To: All Staff
From: Environmental Health
Date: February 7, 2025
Subject: SP-25-00003 Gregerson

SHEET 2 OF 2

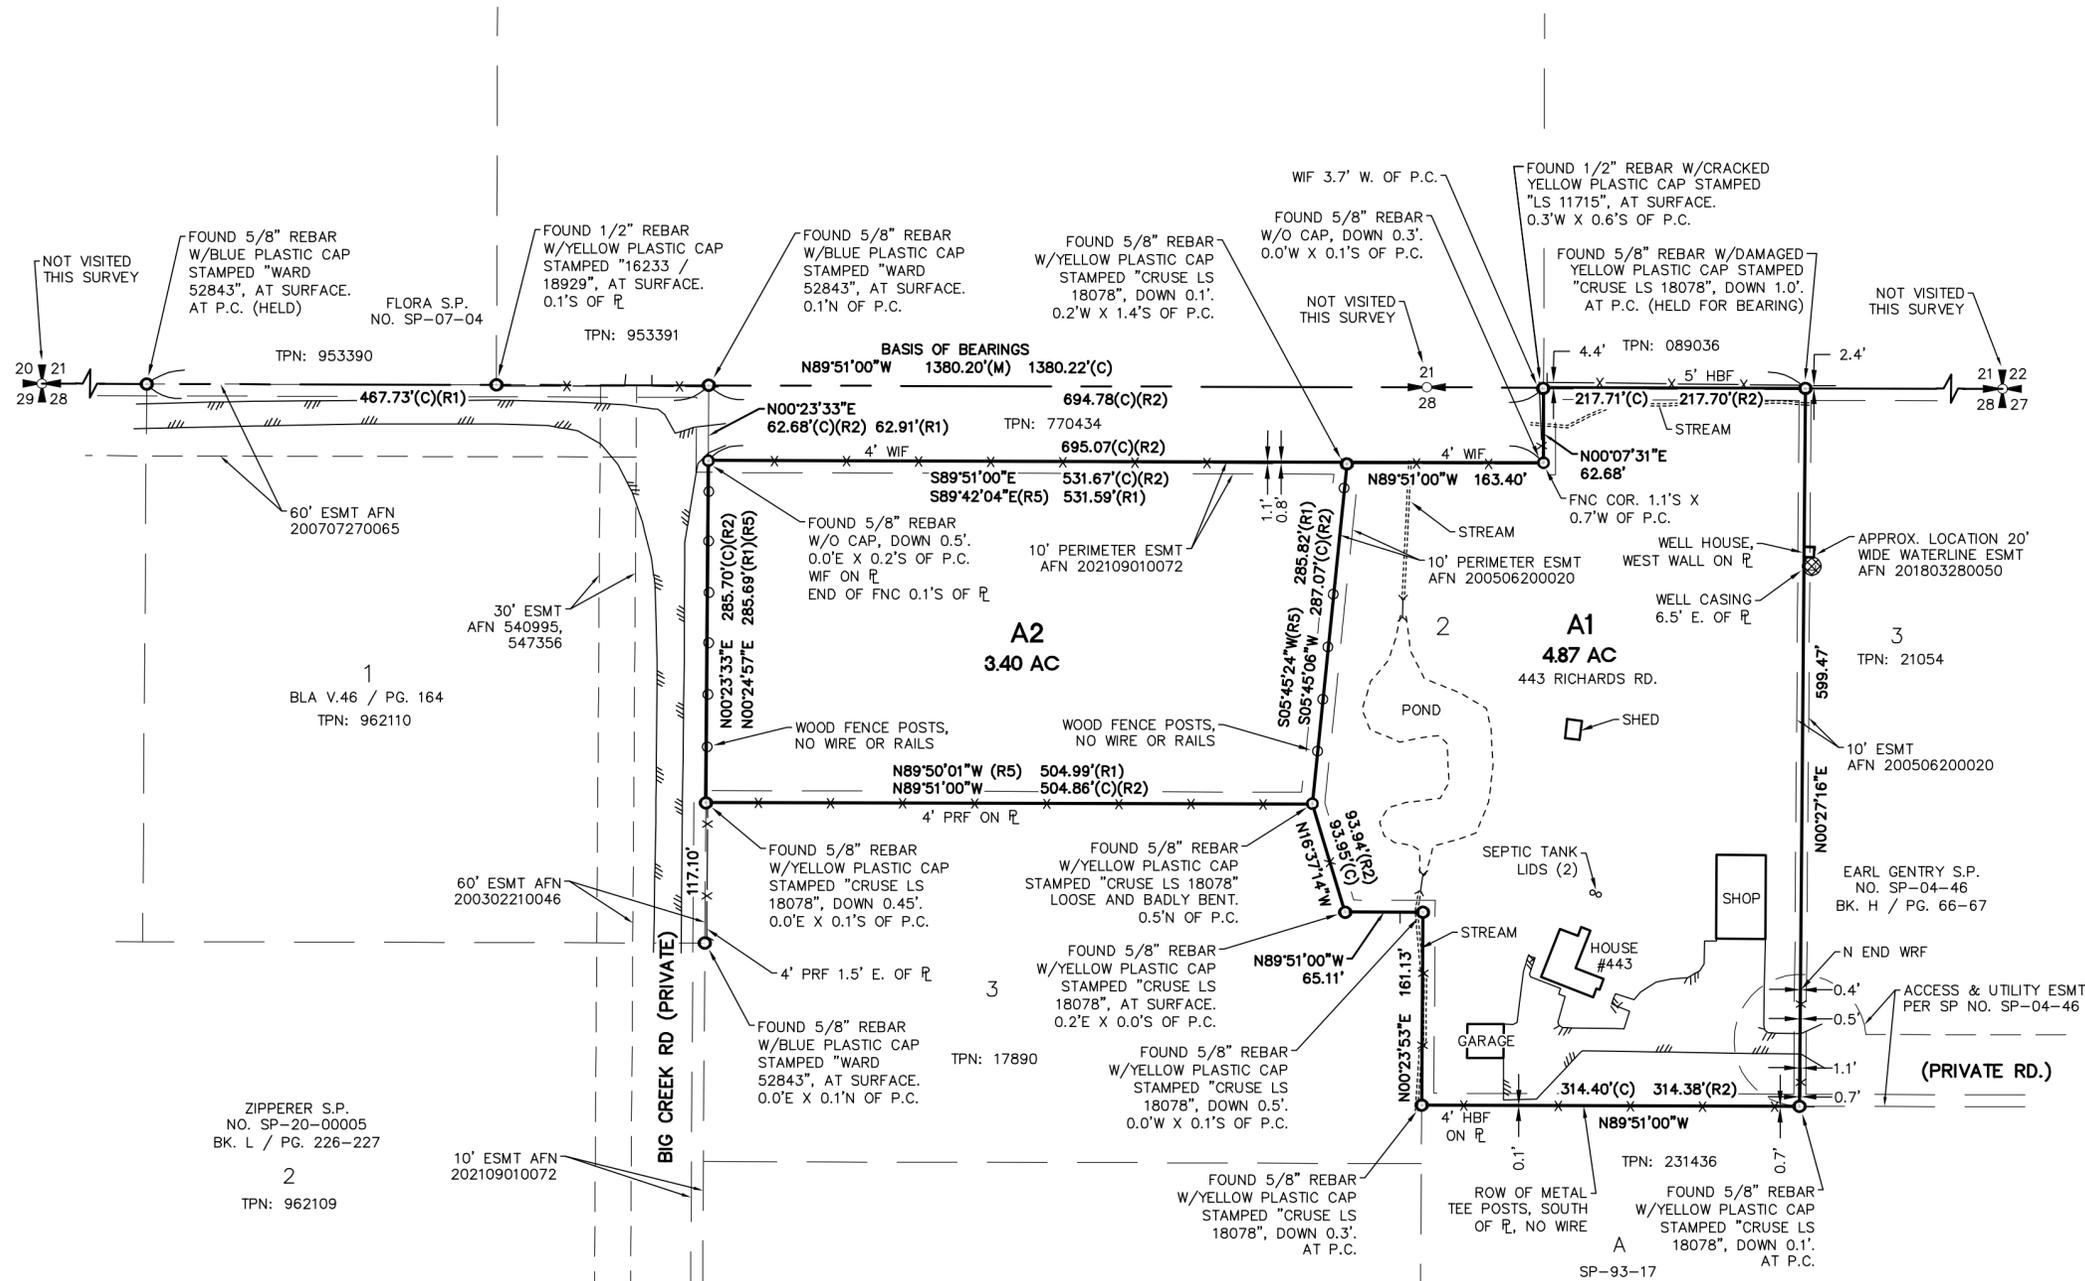
Drinking Water	The existing well ID# BAN 900 is already being used as a shared well. The applicant may choose to drill a new well to serve the new lot A2 or create a Group B water system with the existing well.
Wastewater	A soil log must be recorded for lot A2.
